From: [Nick Goddard](#)
To: [Neil Bearcroft](#)
Cc: [DCAdmin](#)
Subject: FW: 2021/91239 at location 410/412, Birkby Road, Birkby, Huddersfield, HD2 2DN-Proposed dwellings
Date: 14 July 2021 13:44:06
Attachments: [image006.png](#)
[image017.png](#)

[Nick Goddard](#)
Arboricultural Officer

Proposed Site Layout Plan

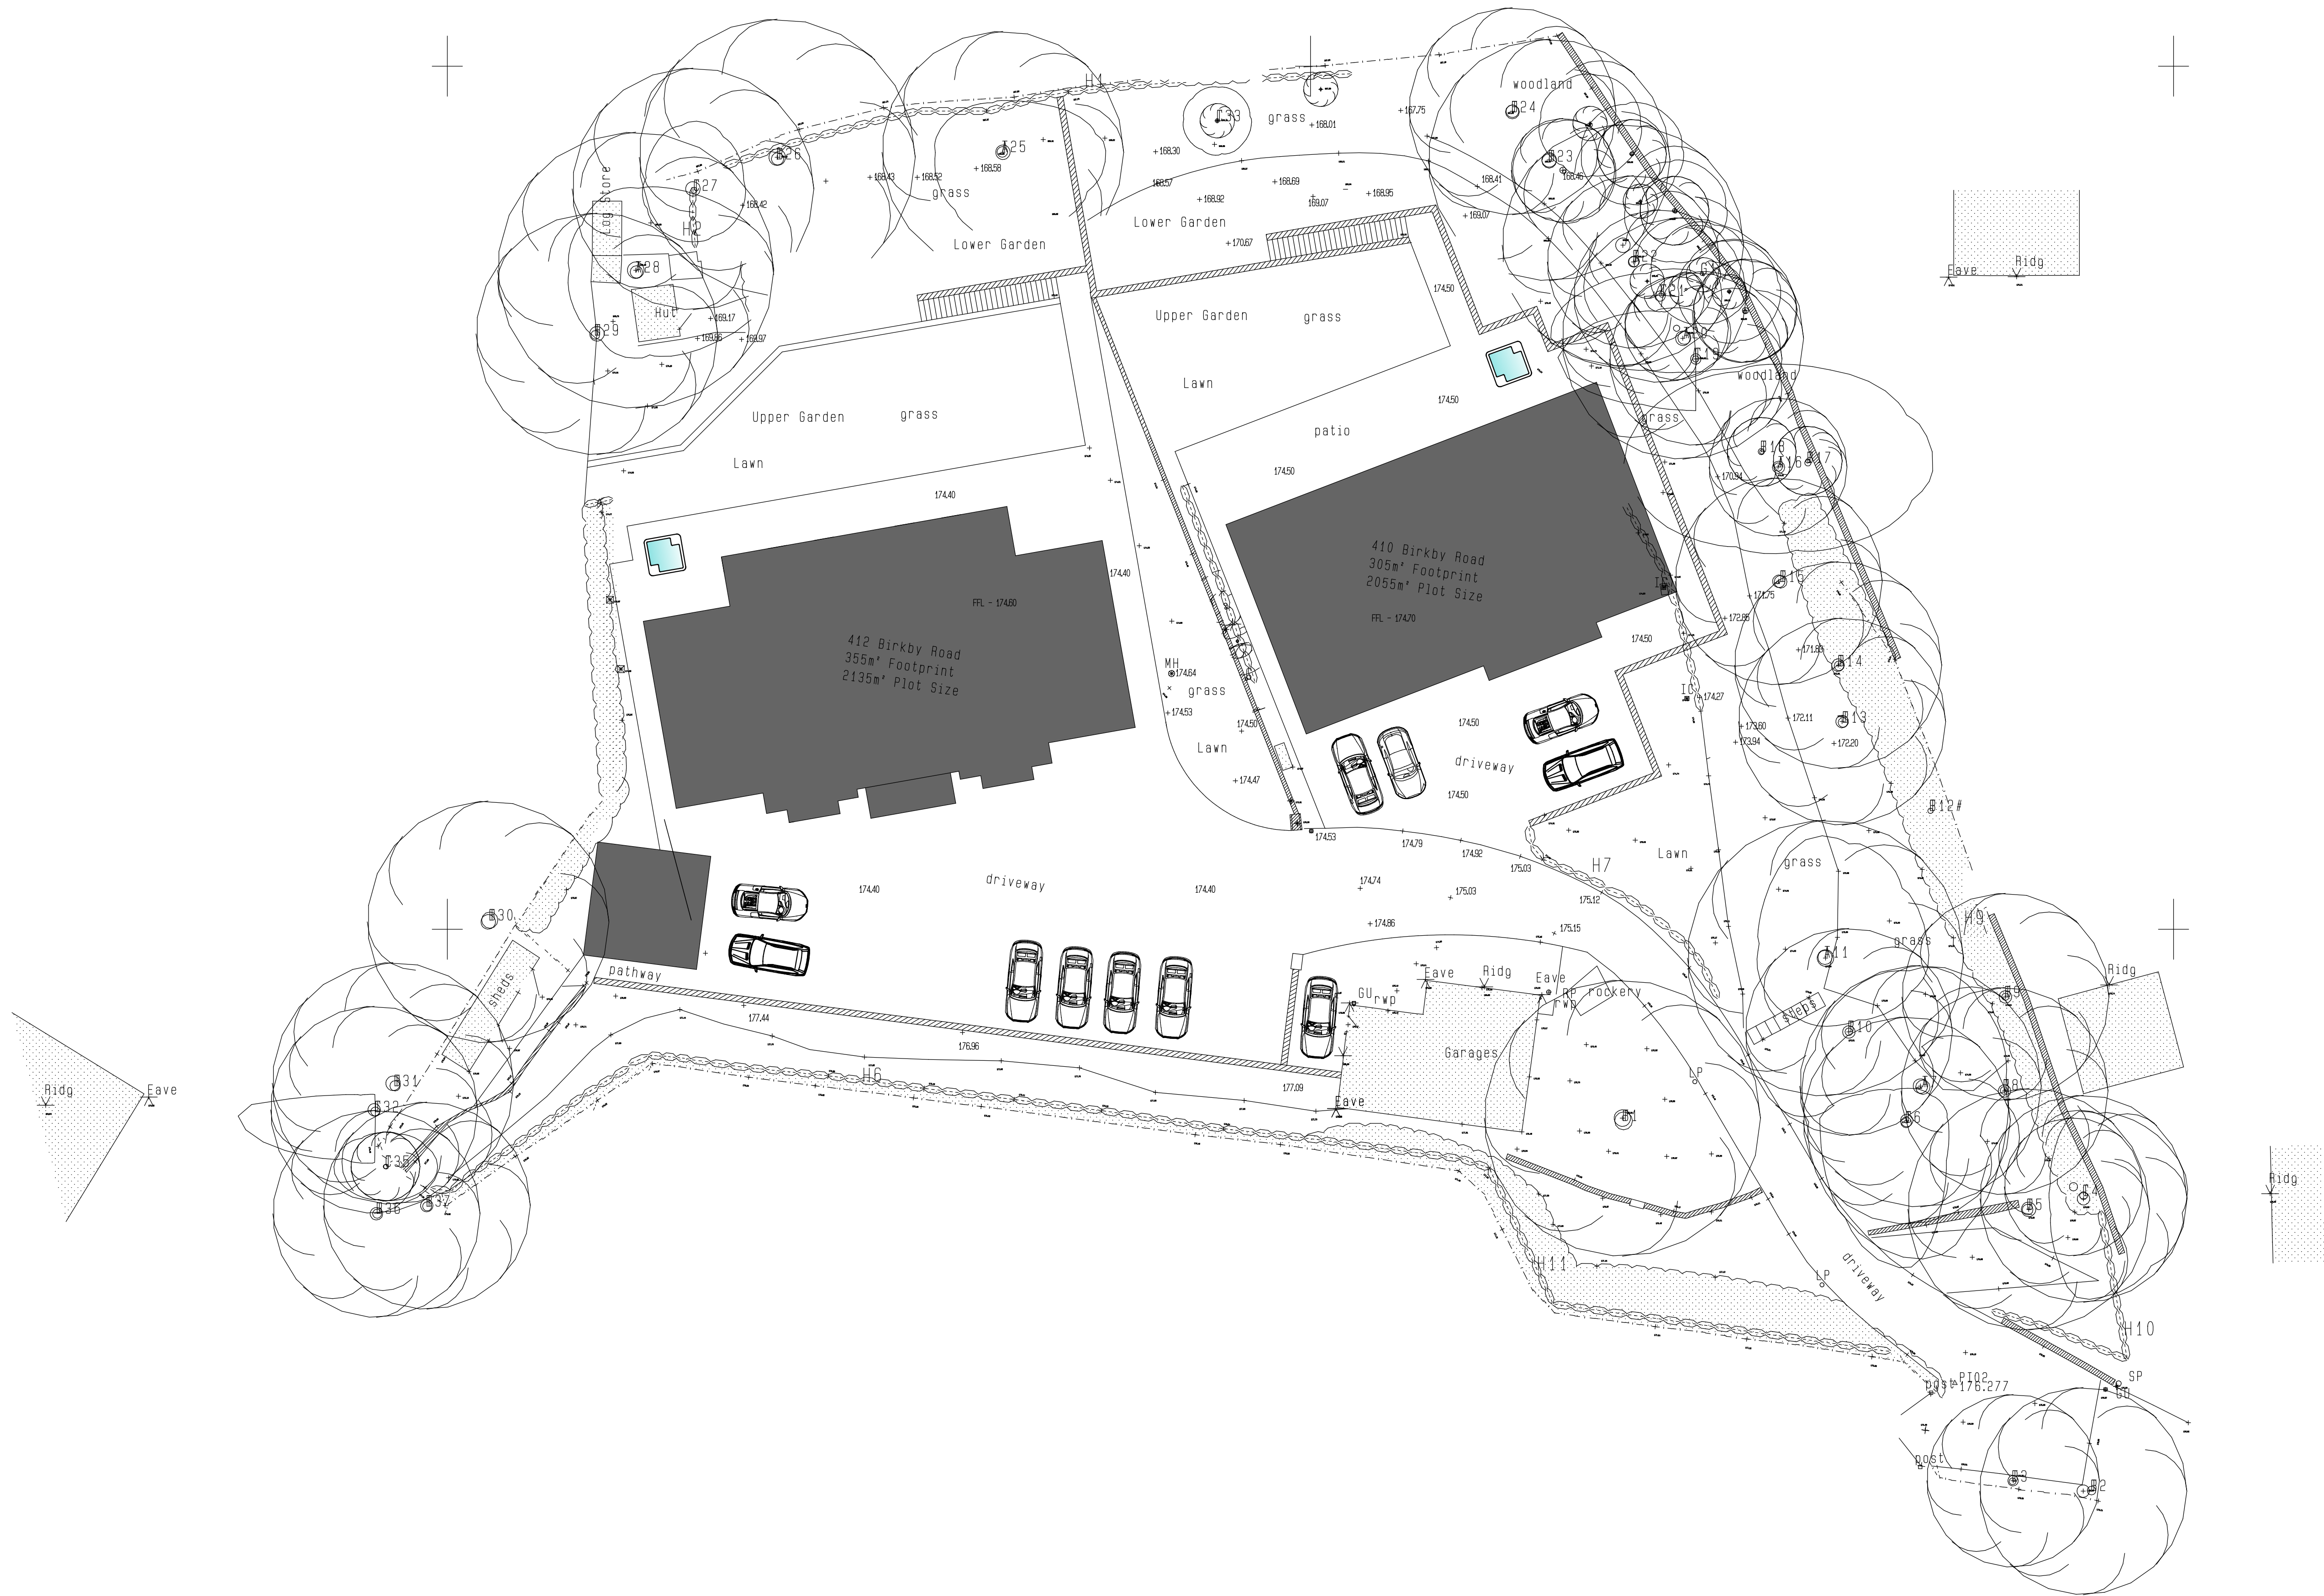
In short, following the changes to the layout and update of the AMS, I am now satisfied that the trees are being retained and can be protected from harm caused by the proposed demolition and construction. This is part due to the relocation of plot 410 to match the existing and the use of the existing retaining feature on the plots eastern side. In addition the garage for plot 412 has been relocated which reduces any risk of harm to adjacent trees there too.

If approved a condition of compliance with the AMS and TPP should be applied, example below if it's needed.

The development shall be completed in accordance with the advice and directions (recommendations) contained in the Arboricultural Impact Assessment and Method Statement reference (Morfe Valley Environmental Ltd, ref MVE/AM_021/2021/03 dated 02/07/21) and Tree Protection Plan (Morfe Valley Environmental Ltd, ref MVE_TPP_01_Rev B). These shall be implemented and maintained throughout the construction phase and retained thereafter.
